From: Paul Cann
Sent: 16 August 2017 16:53
To: Planning.Responses
Subject: RE: Planning Consultation on: AB/77/17/PL

Engineers comments in respect to surface water drainage:

APPLICATION **AB/77/17/PL**

Description of Works: Demolition of existing dwelling & buildings. Erection of a block of 45 sheltered apartments for the elderly (comprising 21 x one bedroom apartments and 24 x two bedroom apartments age restricted to 60 years and over); with associated access, electric buggy/cycle store, refuse bin store & 34 parking spaces. This application affects the character & appearance of the Arundel Conservation Area.

Drainage Strategy Drawing

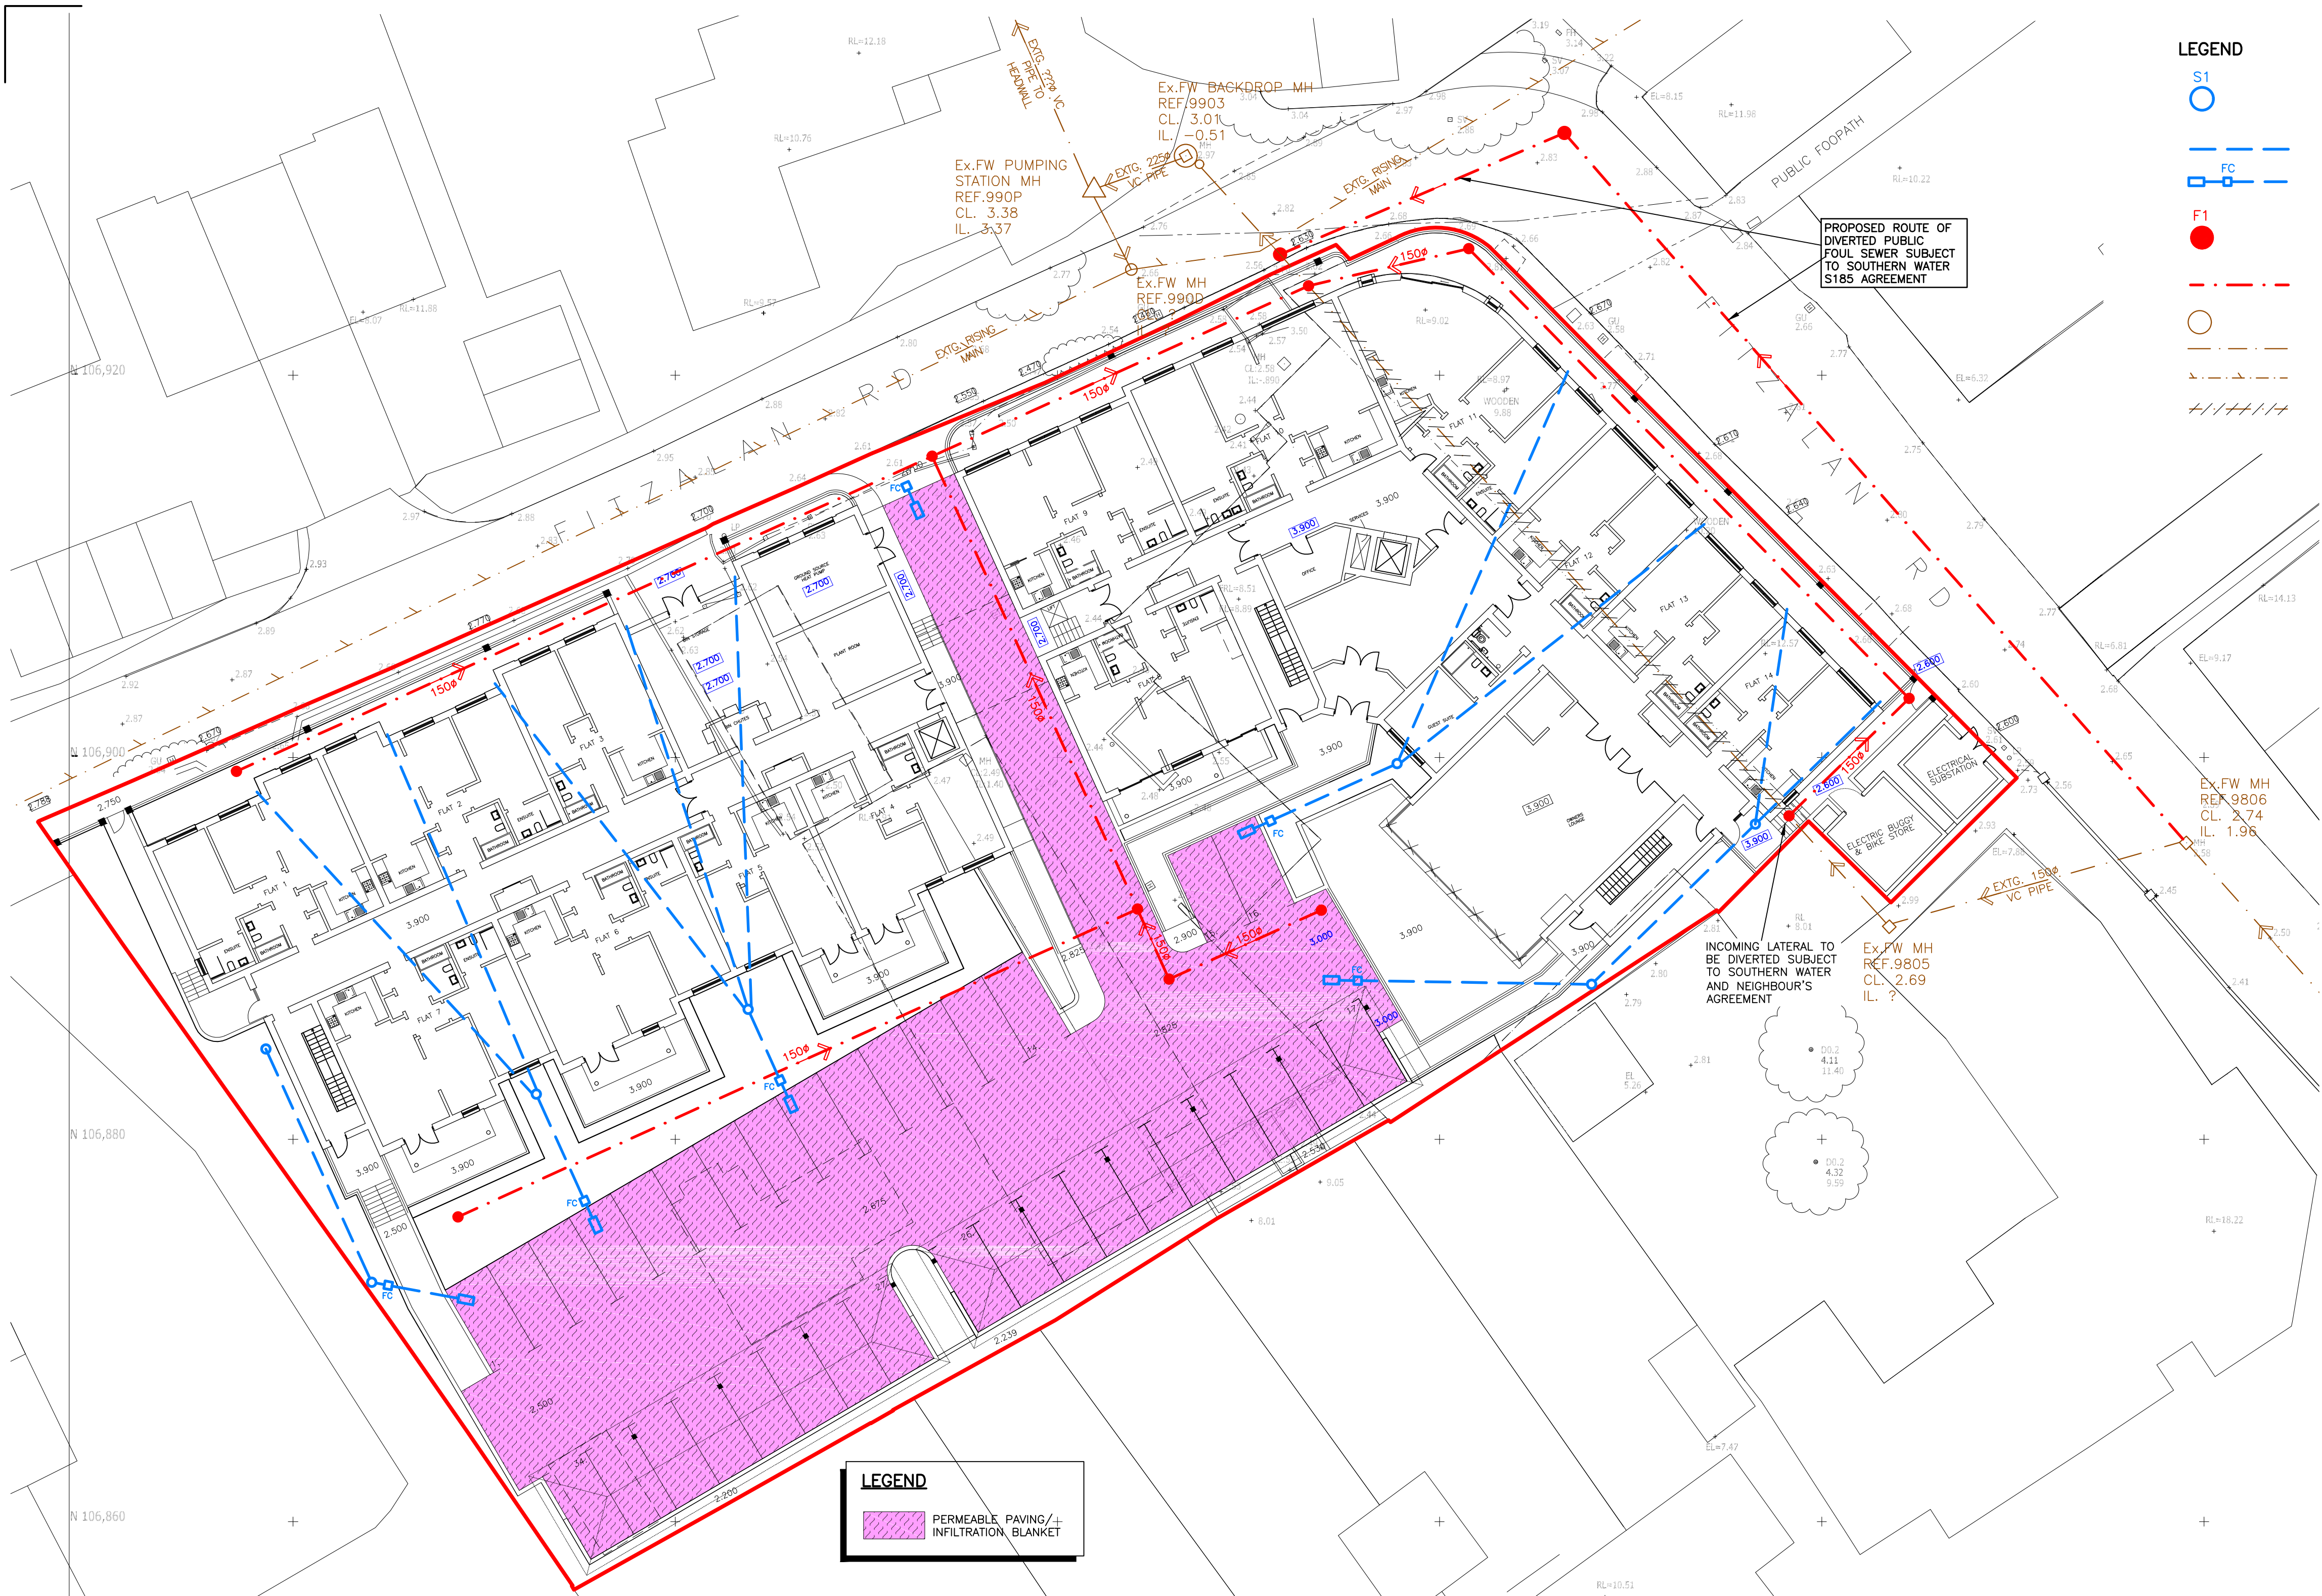
Surface water drainage will be a challenge on this site due to the inherent ground conditions. The proposed shallow infiltration system will be heavily dependent on the results of winter ground water monitoring and winter percolation testing at an agreed depth.

A public foul sewer crosses the site, so Southern Water should be consulted.

Please apply standard condition ENGD2A.

Infiltration rates for soakage structures are to be based on percolation tests undertaken in the winter period and at the location and depth of the proposed structures. The percolation tests must be carried out in accordance with BRE 365, CIRIA R156 or a similar approved method and cater for the 1 in 10 year storm between the invert of the entry pipe to the soakaway, and the base of the structure. It must also have provision to ensure that there is capacity in the system to contain below ground level the 1 in 100 year event plus 30% on stored volumes, as an allowance for climate change. Adequate freeboard must be provided between the base of the soakaway structure and the highest recorded annual groundwater level identified in that location.

Any SuDS or soakaway design must include adequate groundwater monitoring data to determine the highest winter groundwater table in support of the design. The applicant is advised to discuss the extent of groundwater monitoring with the Council's Engineers. Supplementary guidance notes are also enclosed for information.
